*DECK RENOVATION
 107 GRANT STREET
 PORTLAND, MAINE*

Drawing Title:
COVER SHEET AND GENERAL NOTES

Drawing Number:
S.001

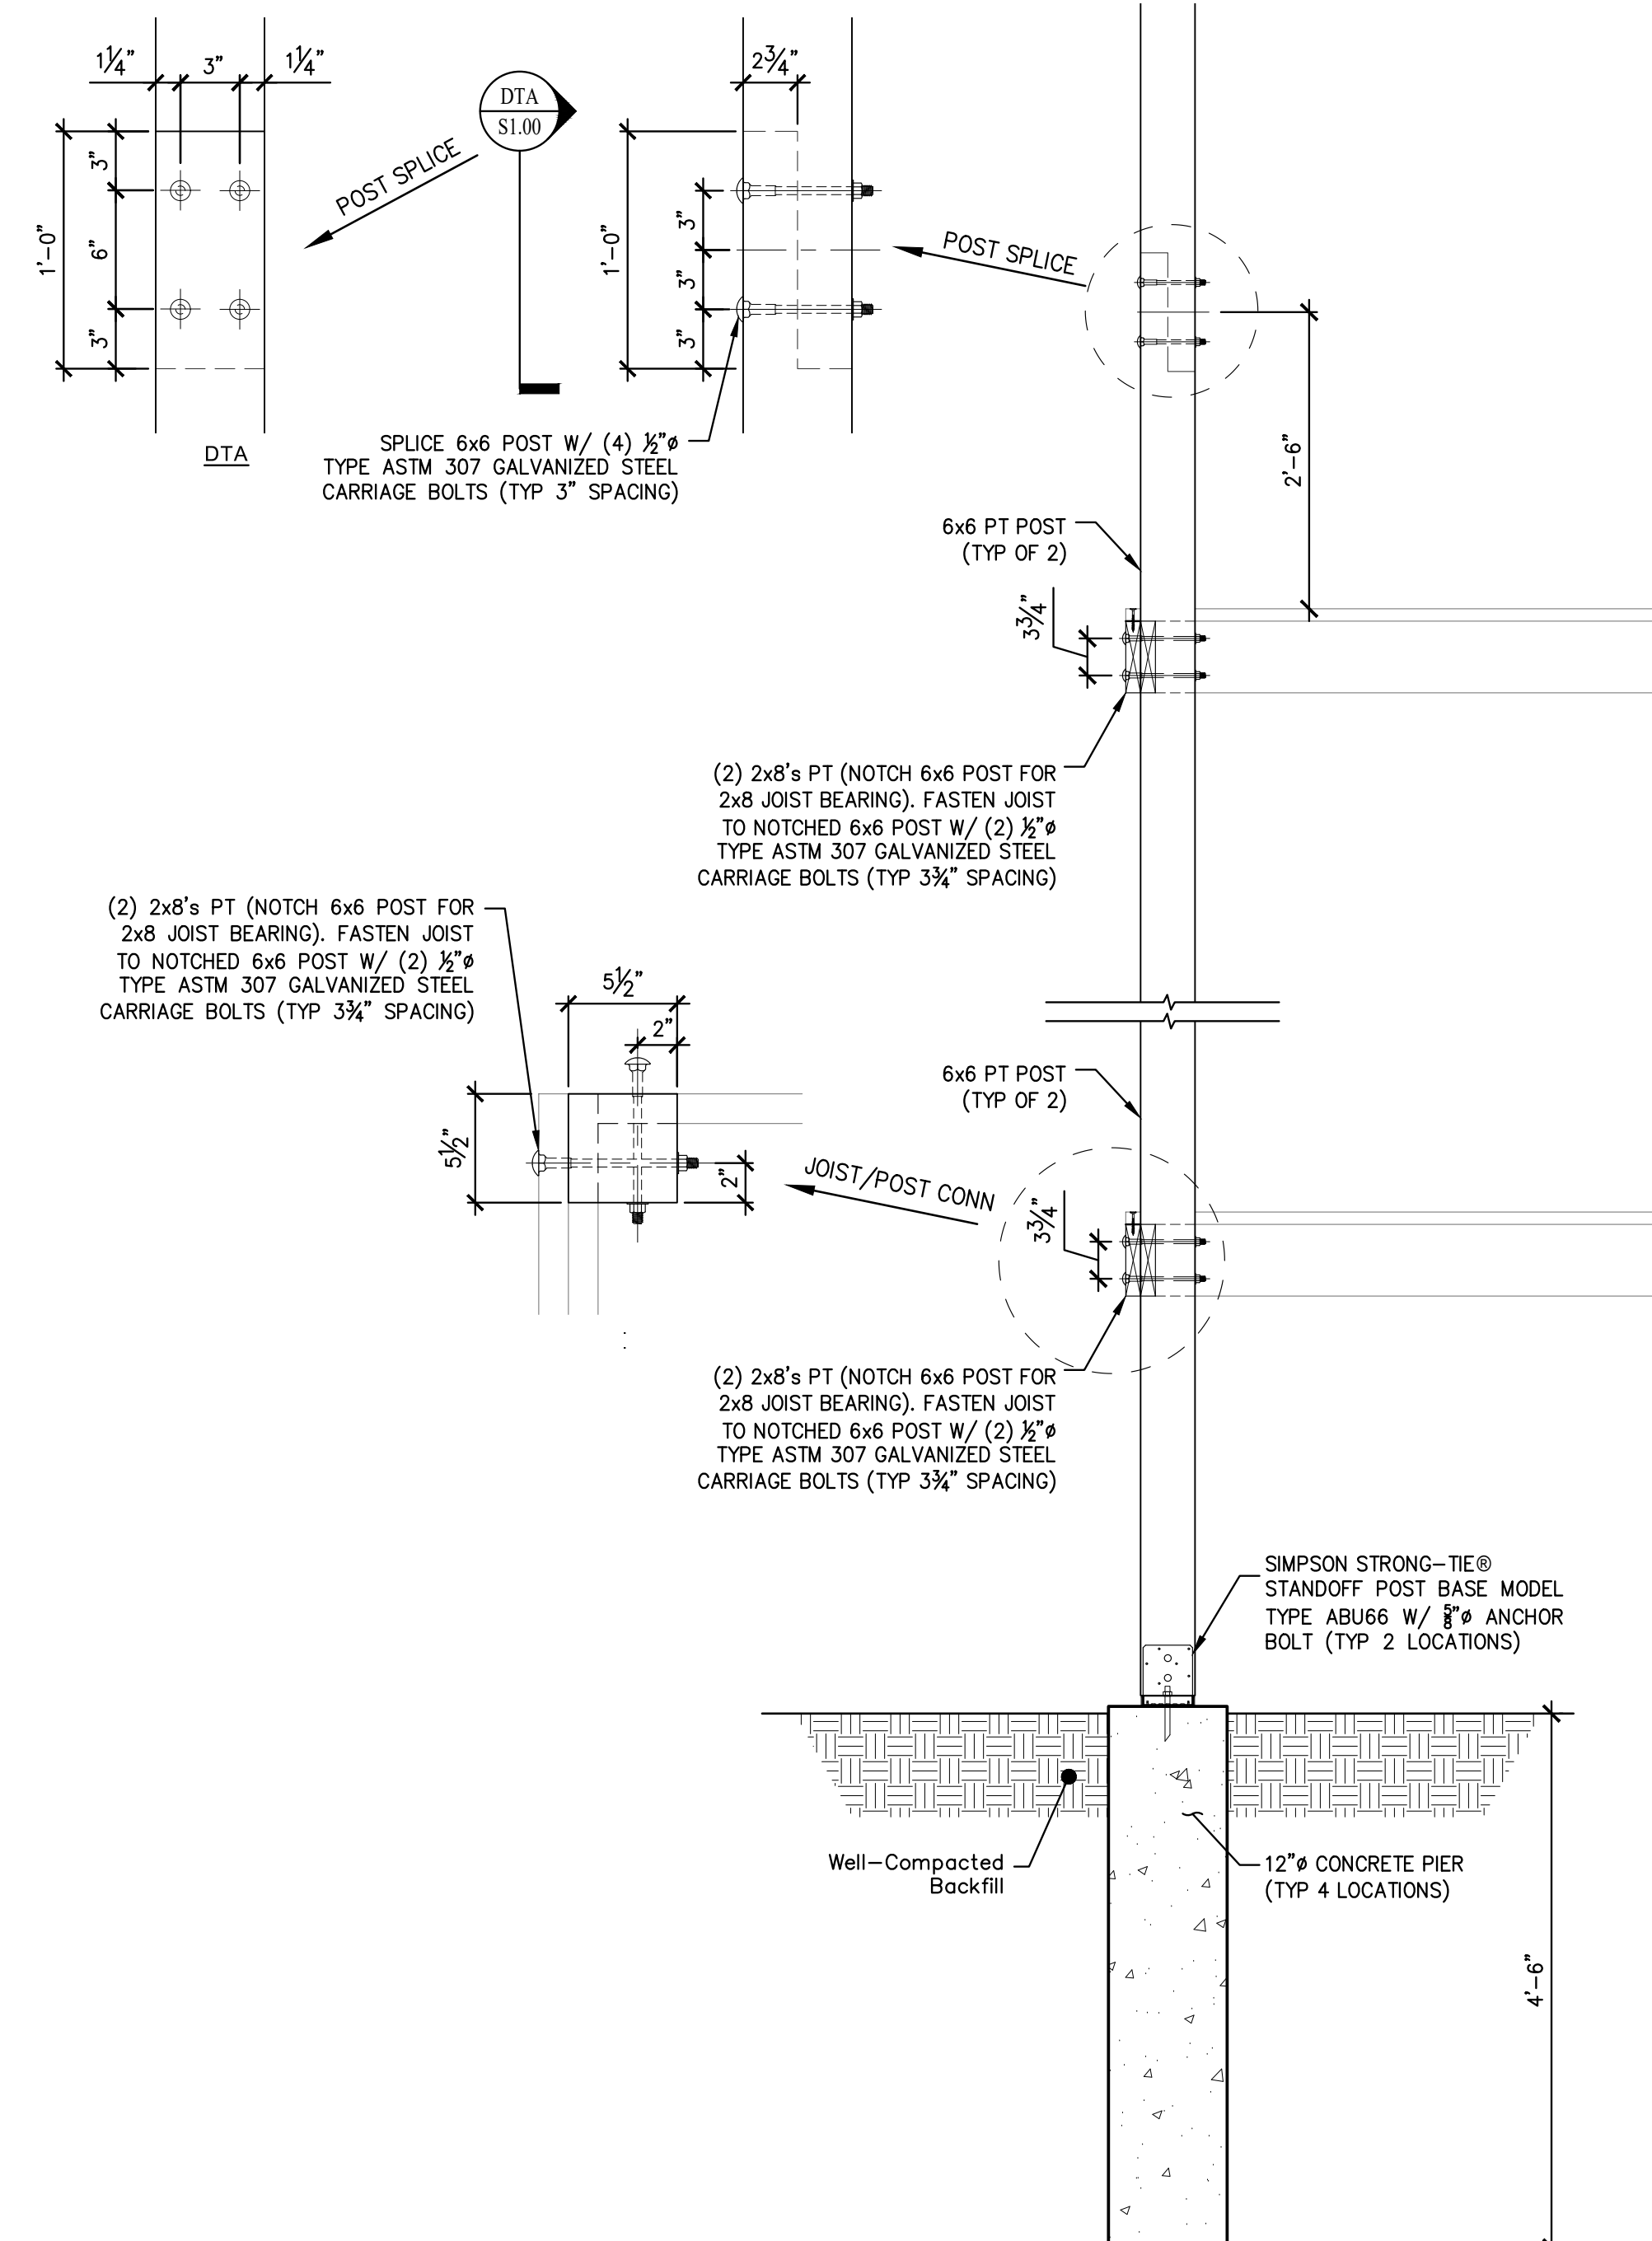
BUILDING CODE INFORMATION:
 THE 2009 EDITION OF THE INTERNATIONAL BUILDING CODE (IBC 2009).
 AMERICAN SOCIETY OF CIVIL ENGINEERS: MINIMUM DESIGN LOADS FOR BUILDINGS AND OTHER STRUCTURES, ANSI/ASCE 7-05, 2005.
 AMERICAN WELDING SOCIETY: STRUCTURAL WELDING CODE - SHEET STEEL, 2nd ED., ANSI/AWS D1.3, 2008.
 Current adopted code: IBC -2015. Please update all information.
